M54 to M6 Link Road

TR010054

**8.8 P(D) Statement of Common Ground
with Hilton, Featherstone & Brinsford
and Shareshill Parish Councils**

March 2021

Title:  
**FIGURE 7.12C  
 VIEWPOINT 8 PHOTOMONTAGE  
 VIEW FROM FIELD GATE  
 ALONG GREAT SAREDON ROAD**

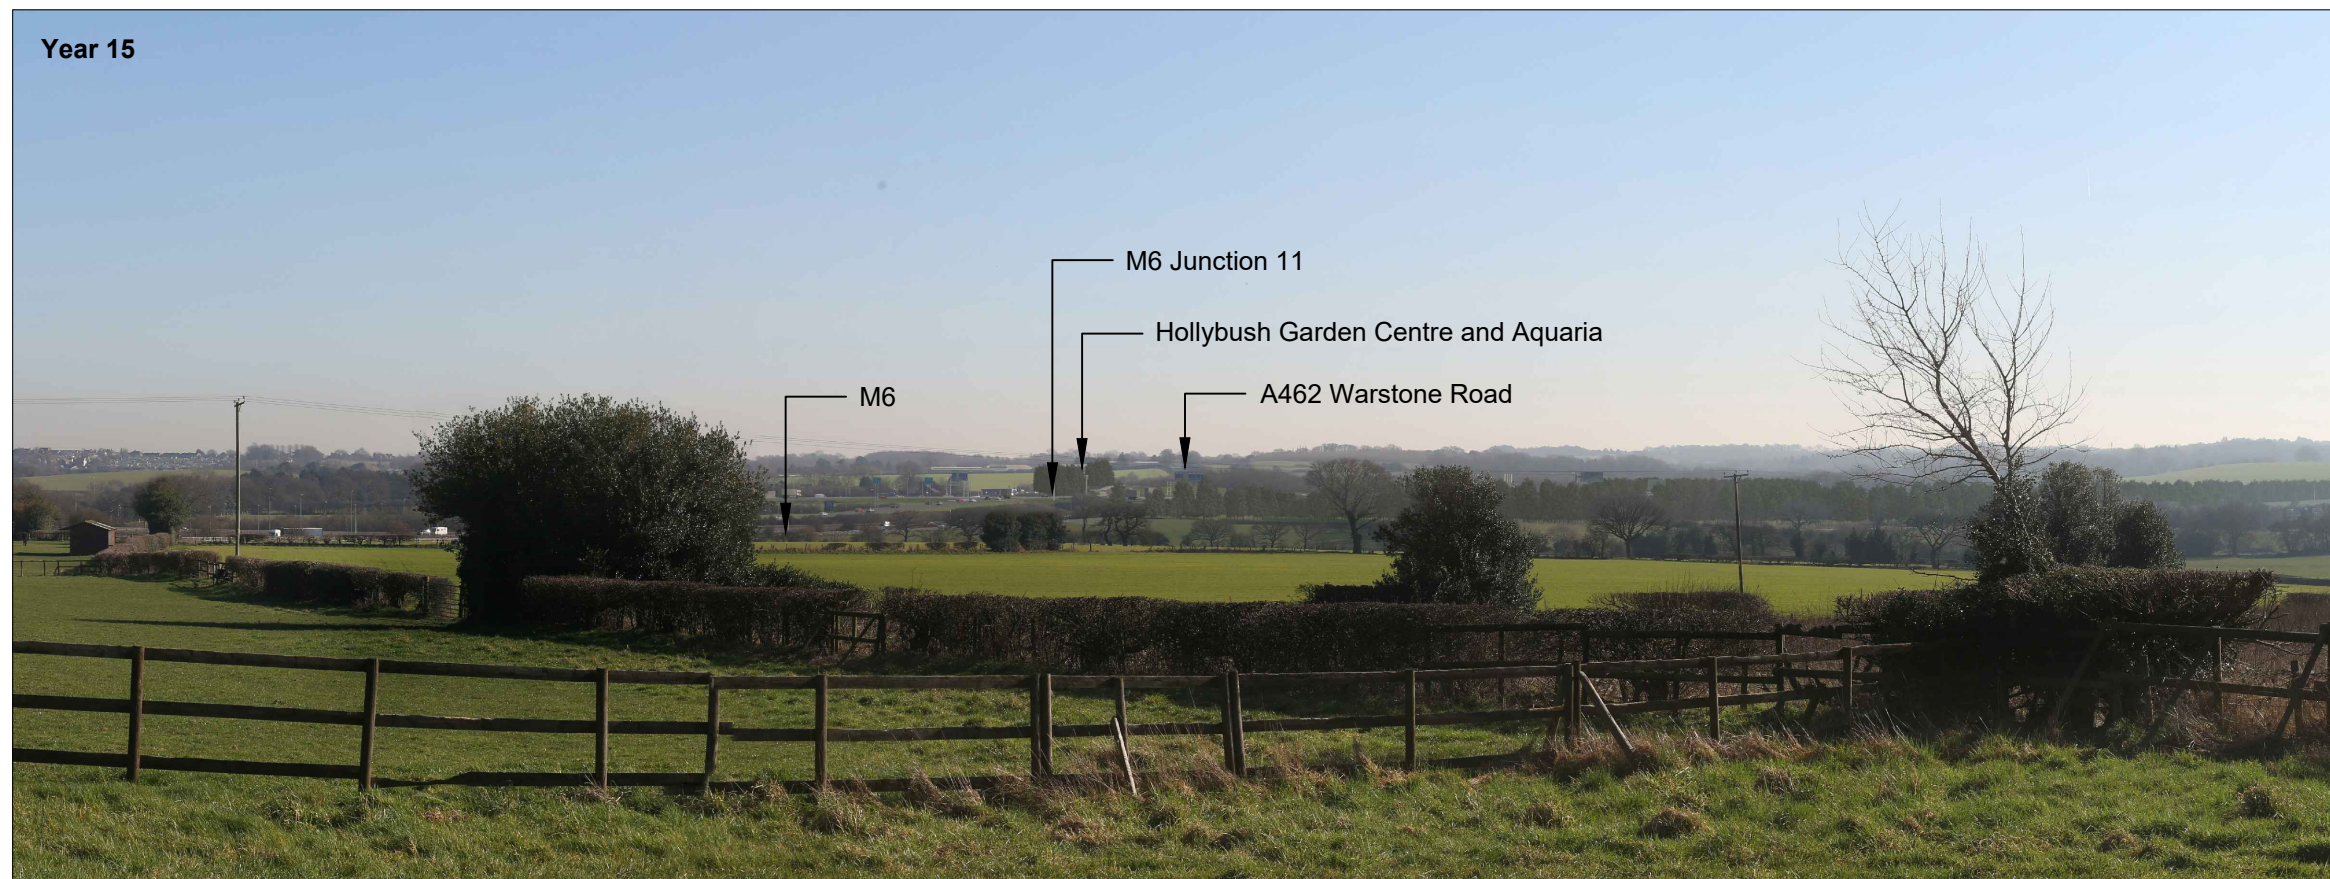
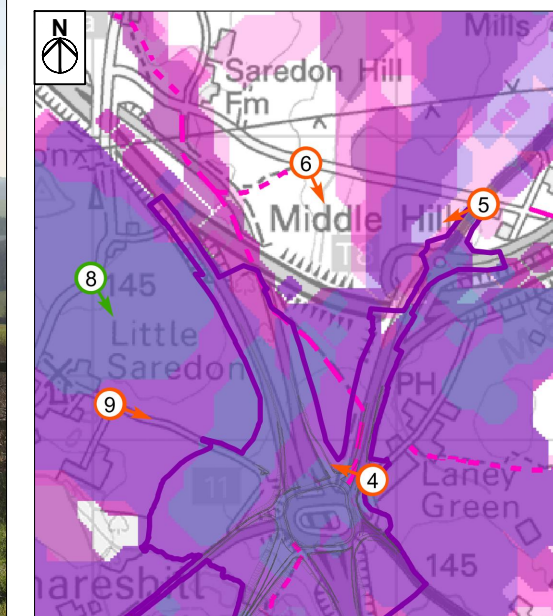
<p>village is proposed.</p> <p>Chapter 7: Landscape and Visual of the ES [APP-046/6.1] assesses views from Shareshill (at the junction with the A460) (VP07) and Little Saredon (VP08 and VP09)- in particular Saredon Hill (VP08). Viewpoints 07 and 09 were not assessed further in the ES due to the limited nature of views towards the Scheme in these locations, viewpoints from these locations are provided as Figure 7.11 and 7.13 of the ES [APP-94 and 096/6.2]. The view from Saredon Hill (VP08) was reproduced as a photomontage to show the proposed landscape mitigation (Figures 7.12C [APP-095/6.2]). On this figure you can see that the strategic planting around Junction 11 has been reinstated to replicate a similar effect to at present. In between the Junction 11 and Hilton Lane, the combination of the Scheme being in cutting and proposed hedgerow planting and woodland planting would reduce the visibility of the road. It was not considered necessary to include additional woodland beyond that proposed, a decision in line with the Staffordshire Landscape Character Assessment for the Settled Plateau Farmlands LCT: 'Large-scale woodlands should be designed to interlock and still allow views through the landscape whilst screening urban edges, power lines, quarries and busy roads'.</p>

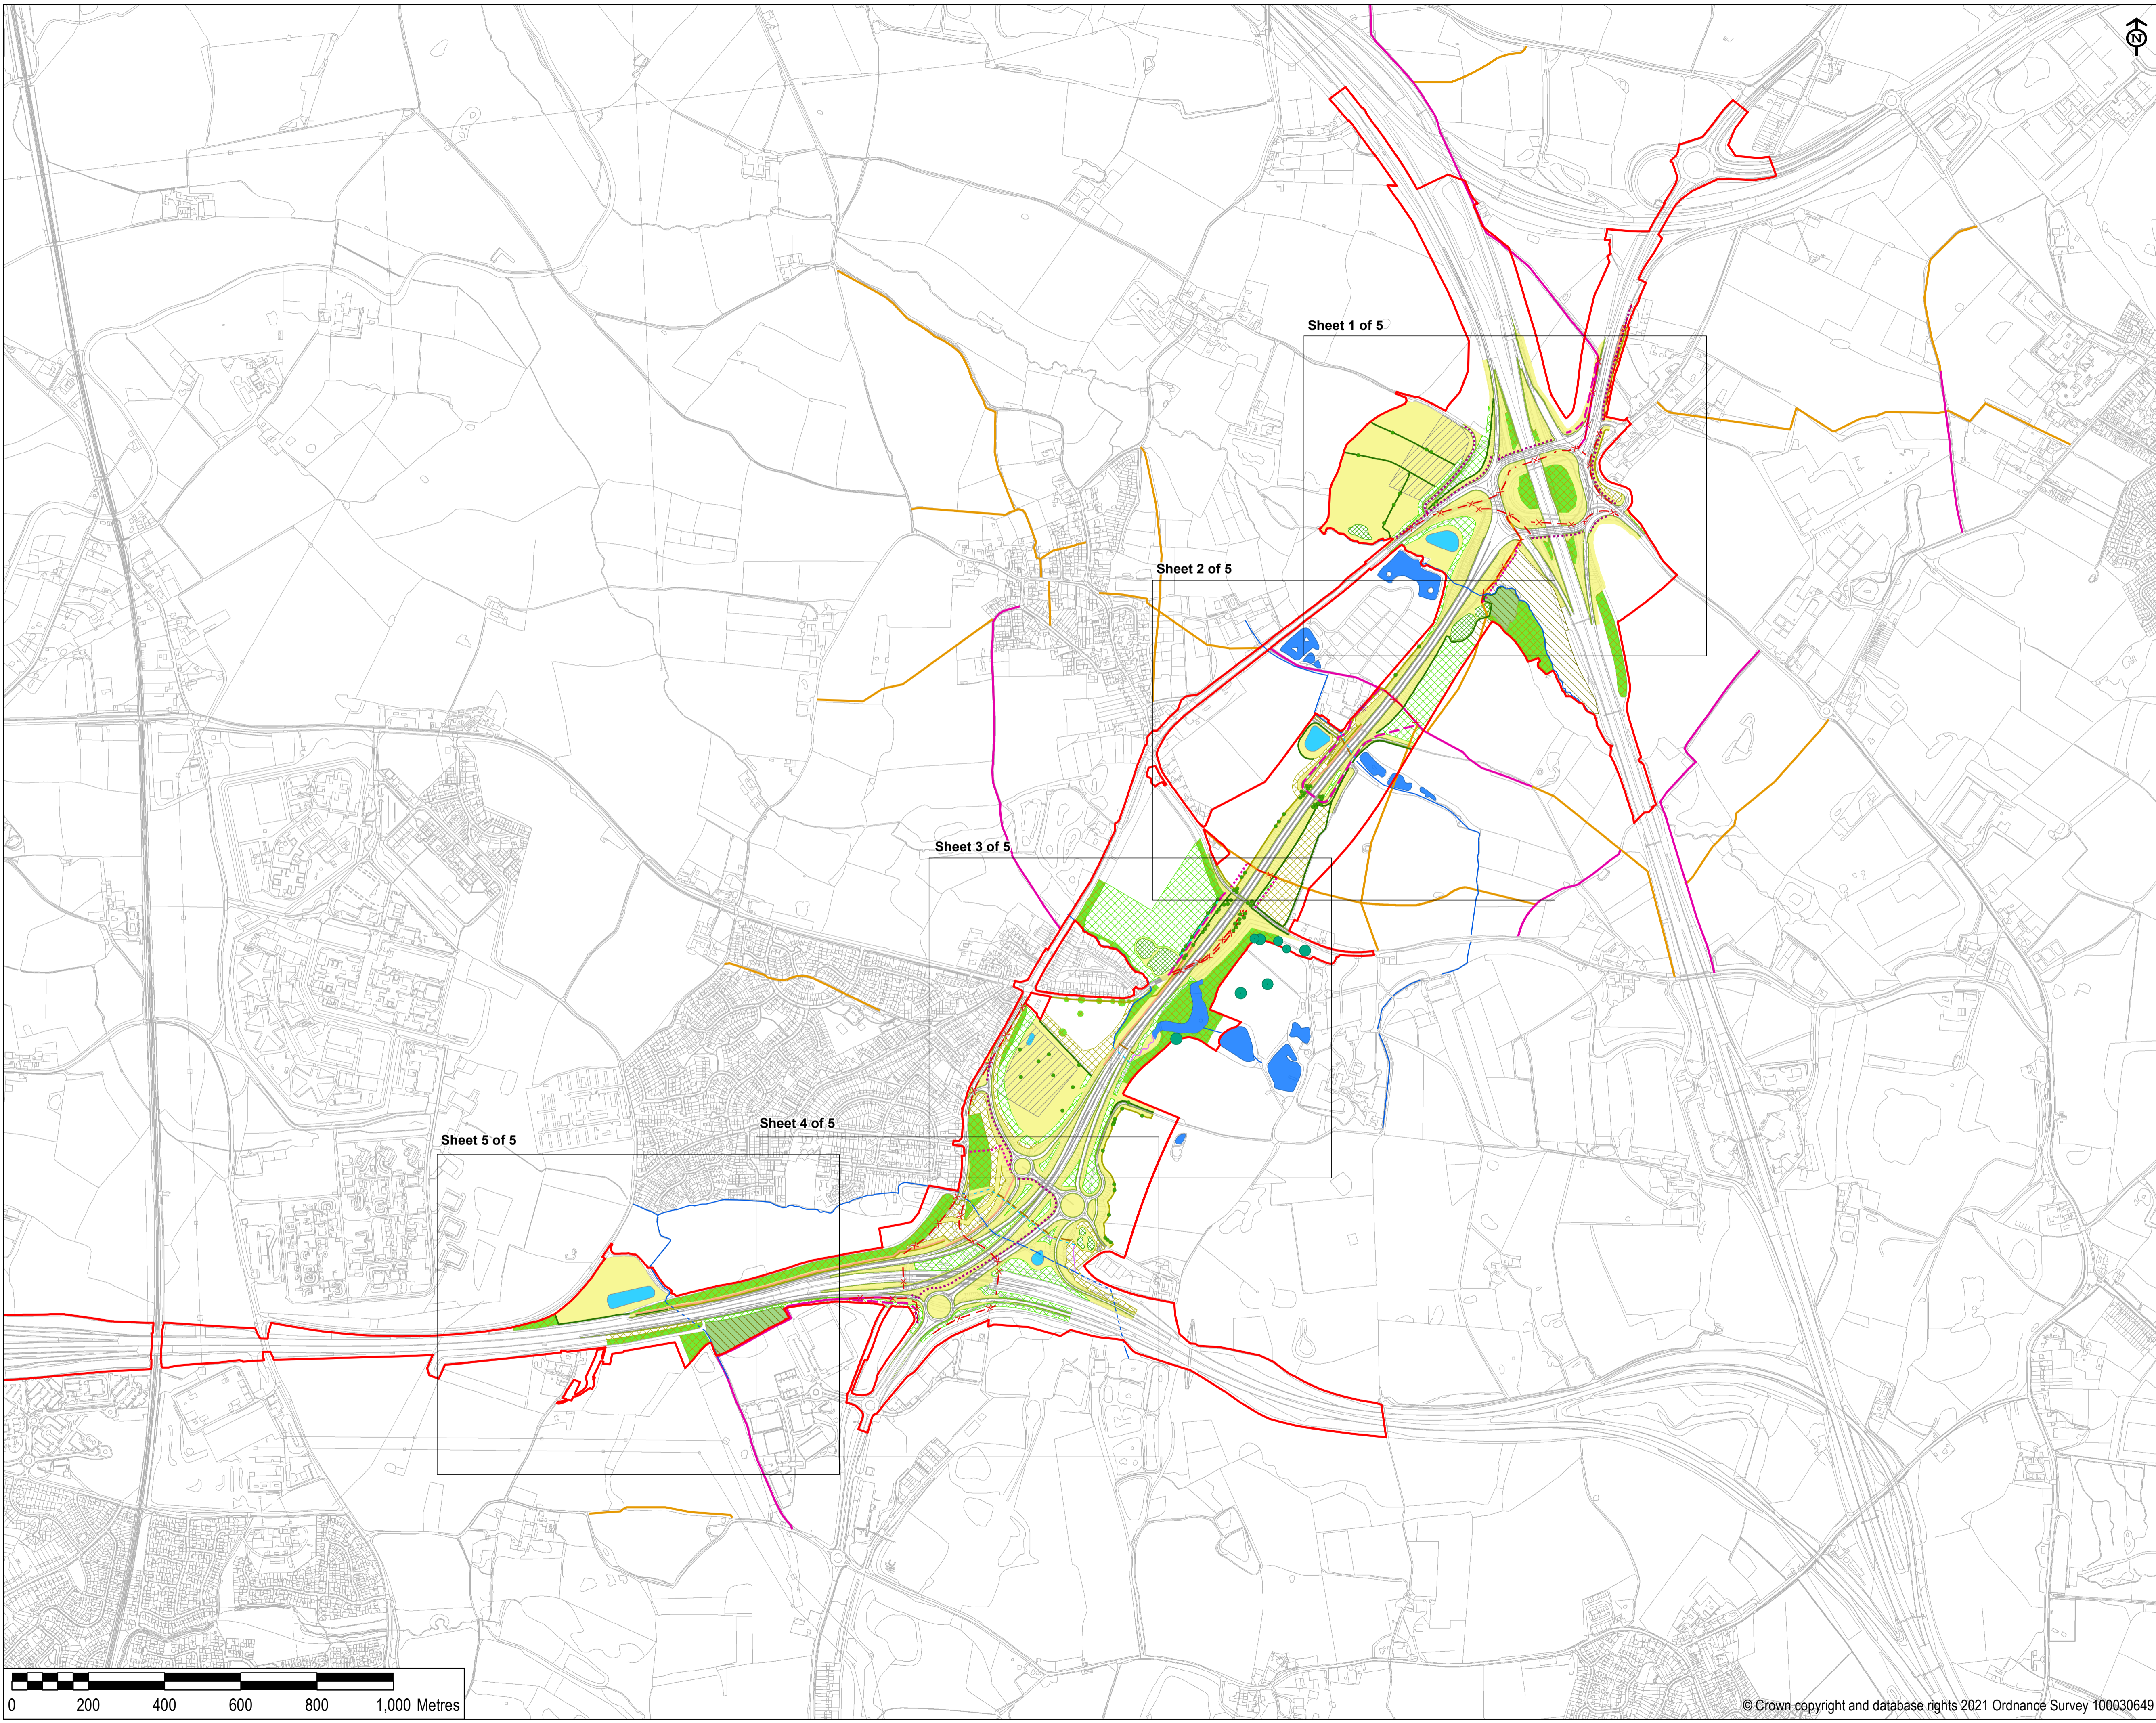
<p>Request for trees to screen Shareshill from increased noise.</p> <p>Following further discussion with Highways England and a review of the Environmental Masterplan, the Parish Councils have confirmed they are happy with the proposed mitigation in this area.</p>	<p>No significant operational traffic noise effects are anticipated in Shareshill village due to the operation of the Scheme. The change in traffic noise levels in Shareshill village due to the implementation of the Scheme is primarily due to two factors: a) the large reduction in traffic flows on the existing A460 at the south-east edge of the village, as traffic is re-routed onto the new link road, which is further away from Shareshill; and b) the small increase in traffic flows on the local roads (Church Road and School Lane) within the village due to re-routing of traffic in/out of the village once the junction with the A460 is relieved of the existing high traffic flows with the Scheme.</p> <p>The noise assessment is based on the impact at the worst affected facade of each residential property i.e. if one facade experiences an increase in traffic noise levels but all the other facades experience a decrease then the impact at the property is assessed based on the one which experiences an increase. On this basis the majority of properties in Shareshill village are anticipated to experience a negligible i.e. less than 1 dB (LA10,18h) increase in traffic noise in the Scheme opening year (2024) due to the implementation of the Scheme. At a small number of properties located very close to Church Road, the increase is at the bottom end of the minor category. It should be noted that traffic flows on the local roads within Shareshill village are low both with and without the Scheme in</p>	Agreed	Agreed

<p>RR-025 states that more woodland is needed along the perimeter of the link road between Hilton Lane rising up to Junction 11 on the western side in order to mitigate the noise and visual effect from the link road up on the village of Shareshill.</p> <p>Following further discussion with Highways England and a review of the Environmental Masterplan, the Parish Councils have confirmed they are happy with the proposed mitigation in this area.</p>	<p>No significant operational traffic noise effects are anticipated in Shareshill once the Scheme is operational.</p> <p>The change in traffic noise levels within the village are as a result of two factors: a) the large reduction in traffic flows on the existing A460 at the south-east edge of the village, as traffic is re-routed onto the new link road, which is further away from Shareshill; and b) the small increase in traffic flows on the local roads (Church Road and School Lane) within the village due to re-routing of traffic in/out of the village once the junction with the A460 is relieved of the existing high traffic flows with the Scheme.</p> <p>The noise assessment is based on the impact at the worst affected facade of each residential property i.e. if one facade experiences an increase in traffic noise levels but all the other facades experience a decrease then the impact at the property is assessed based on the one which experiences an increase. On this basis the majority of properties in Shareshill are anticipated to experience a negligible i.e. less than 1 dB (LA10,18h) increase in traffic noise in the Scheme opening year (2024) due to the implementation of the Scheme. At a small number of properties that are very close to Church Road the increase is at the bottom end of the minor category (approximately 1.0-1.1dB change).</p>	Agreed	Agreed
